**Application by Rosefield Energy Farm Limited for an order  
granting development consent for the Rosefield Solar Farm**

**(EN010158)**

**Written Representation on behalf of the**

**Claydons Solar Action Group (CSAG)**

TITLE:
FIGURE 10.4
DISTRICT LANDSCAPE CHARACTER TYPES AND AREAS

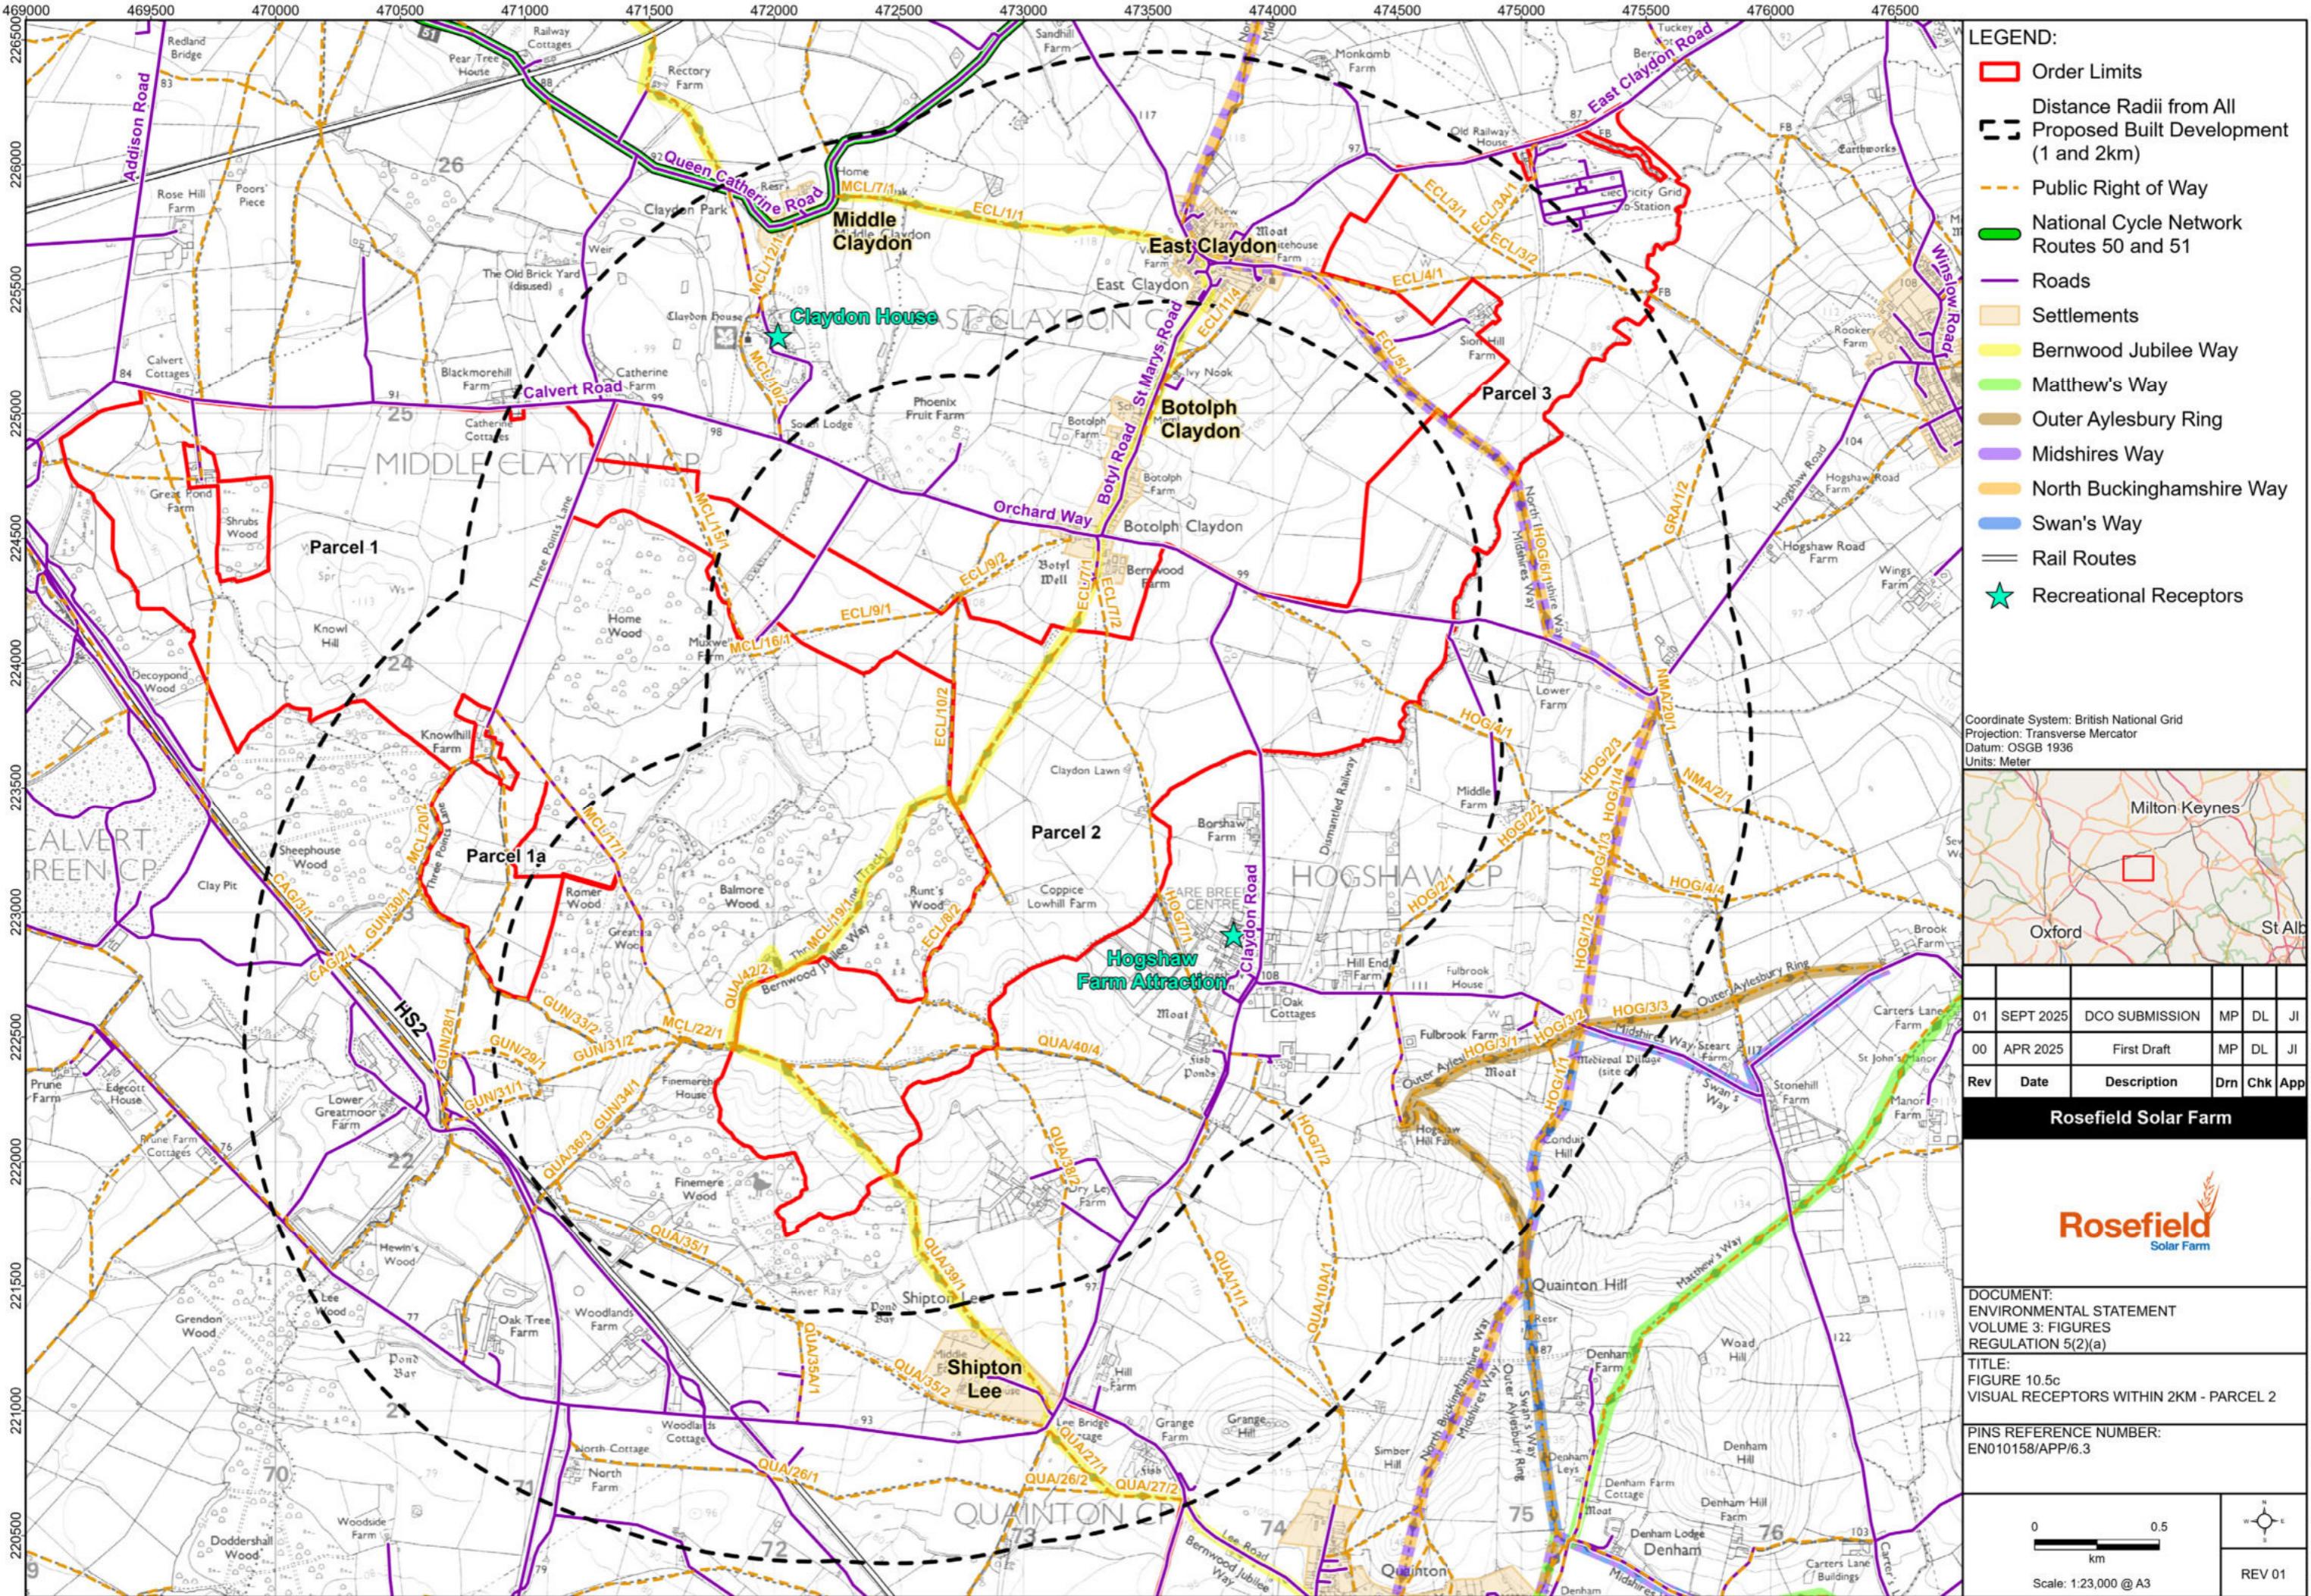
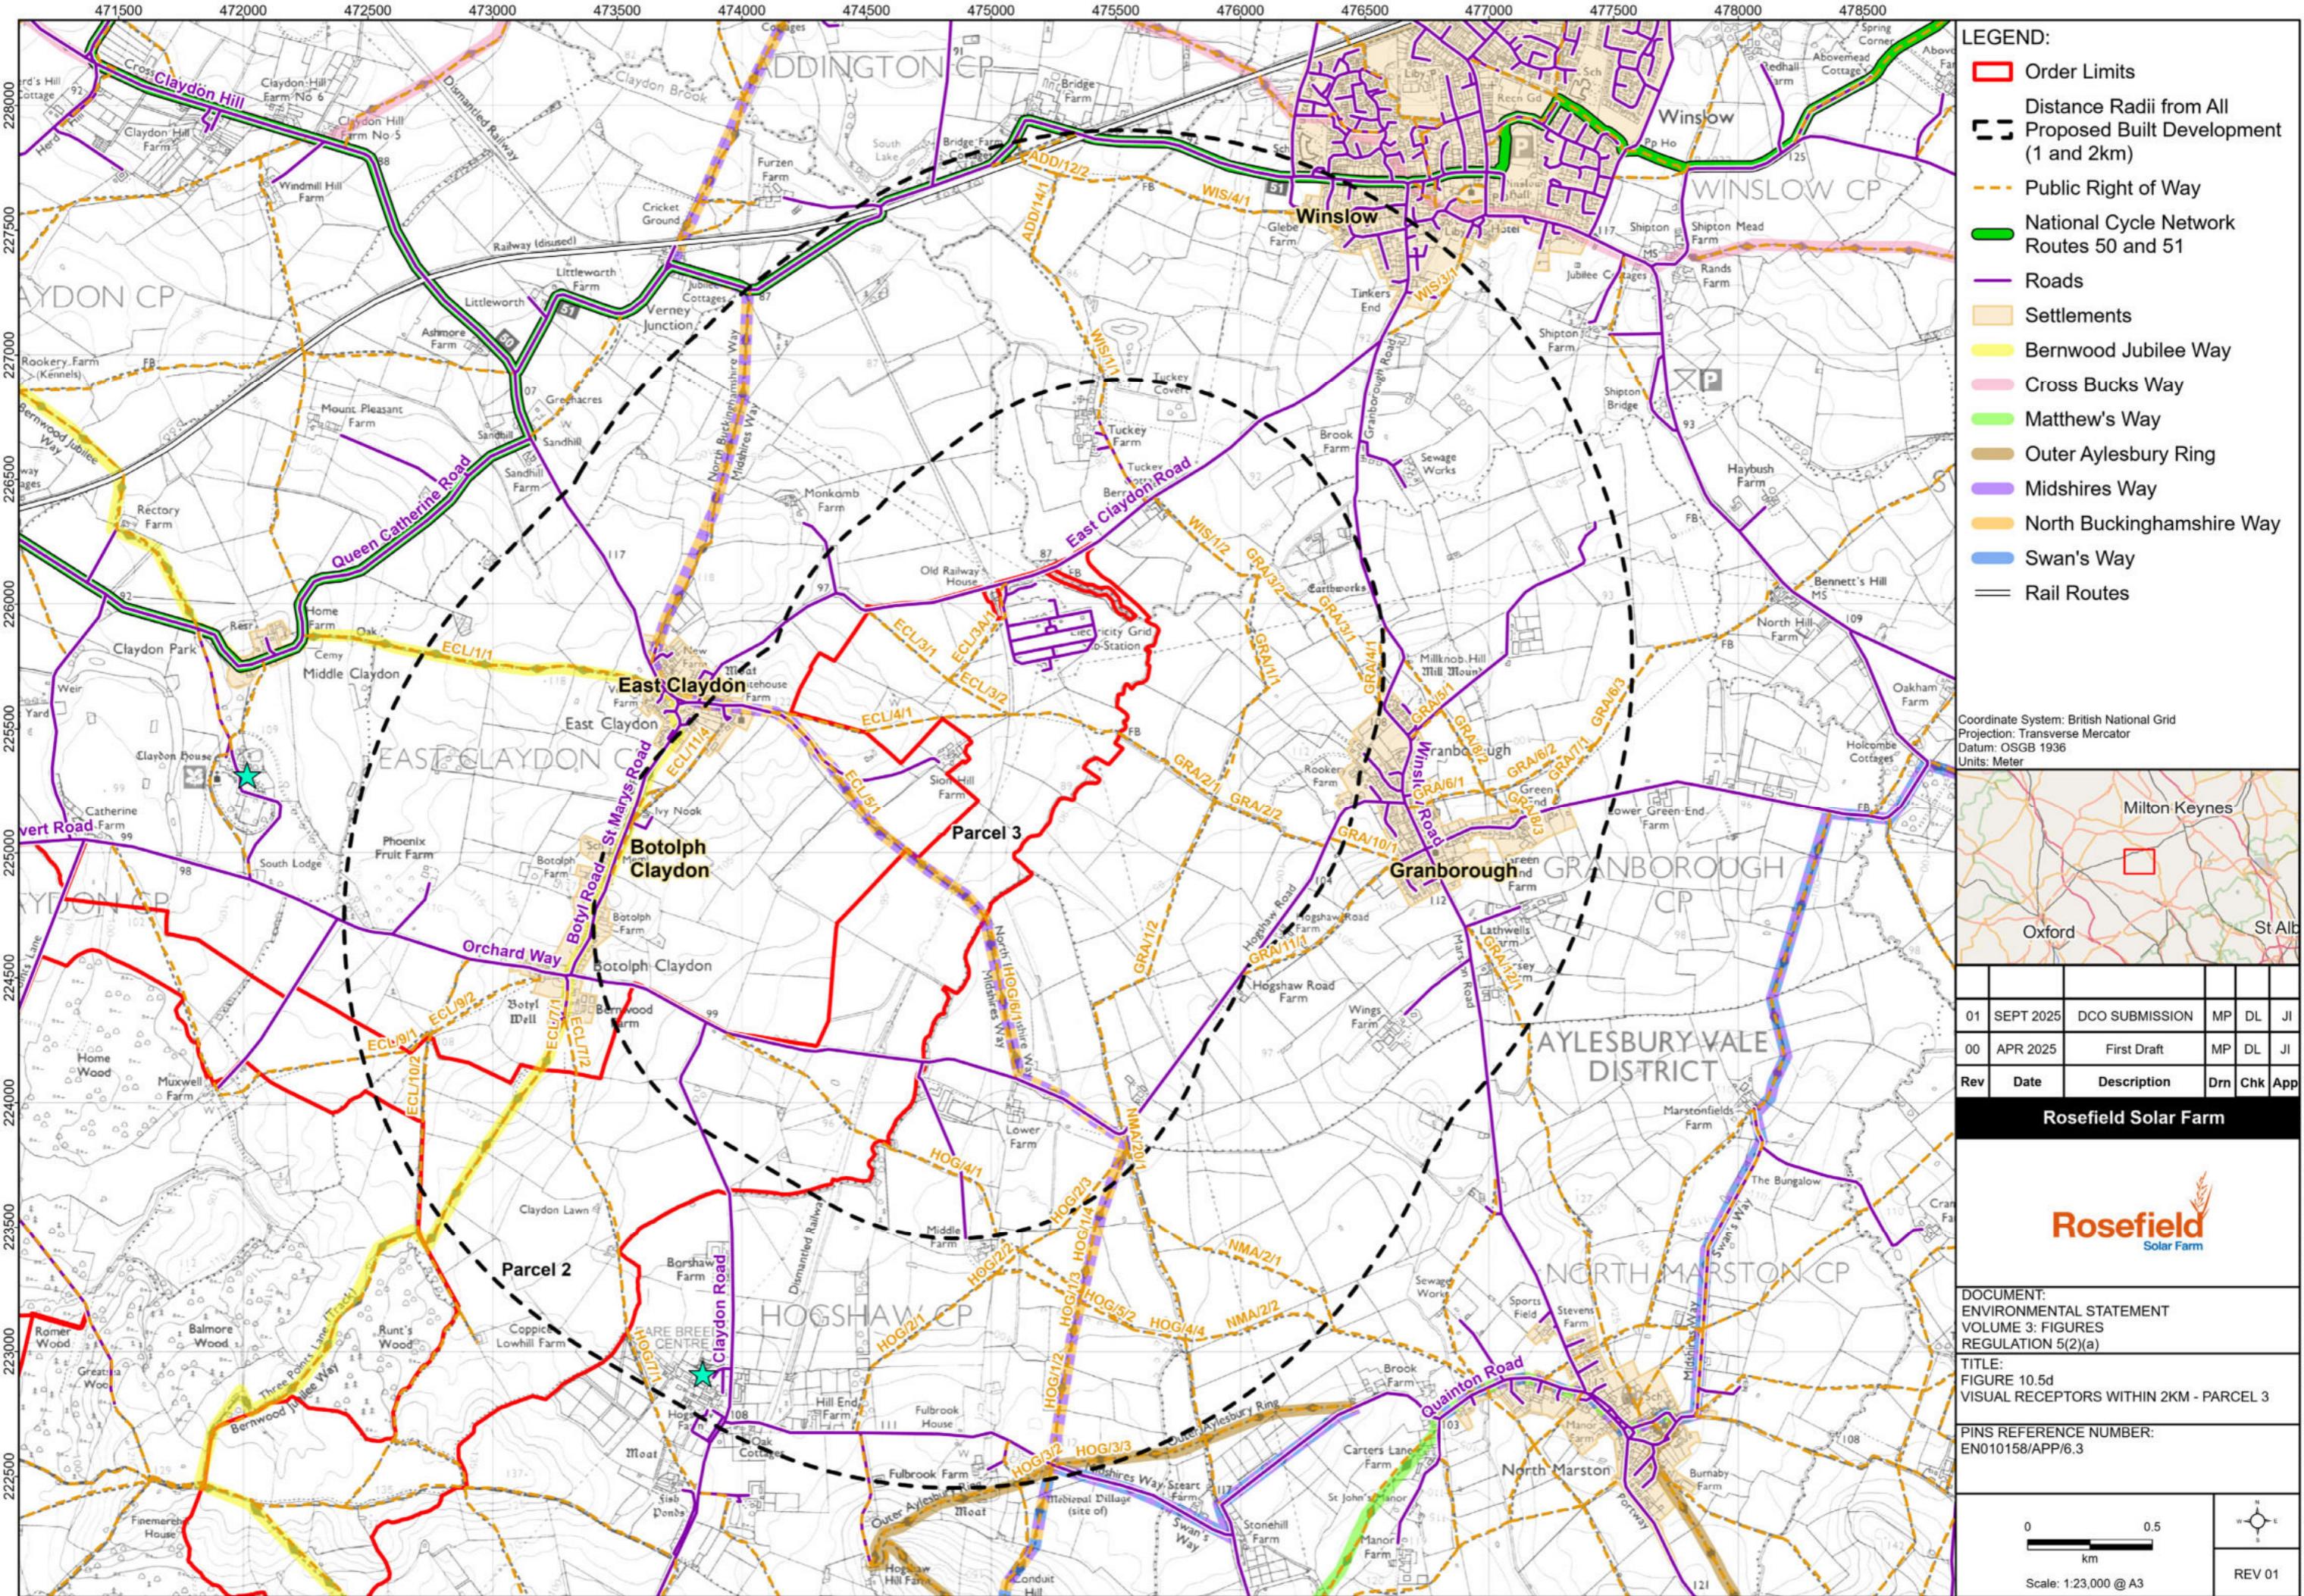
69. The hilly topography is also evident from the Applicant's LVIA Fig.10.4, which shows that the hills and slopes within the Order Limits are rare in these landscapes, predominantly flat clay vales and plateaux. (Environmental Statement Volume 3 Landscape and Visual Figures 10.1 - 10.26) **(AS-031)**.
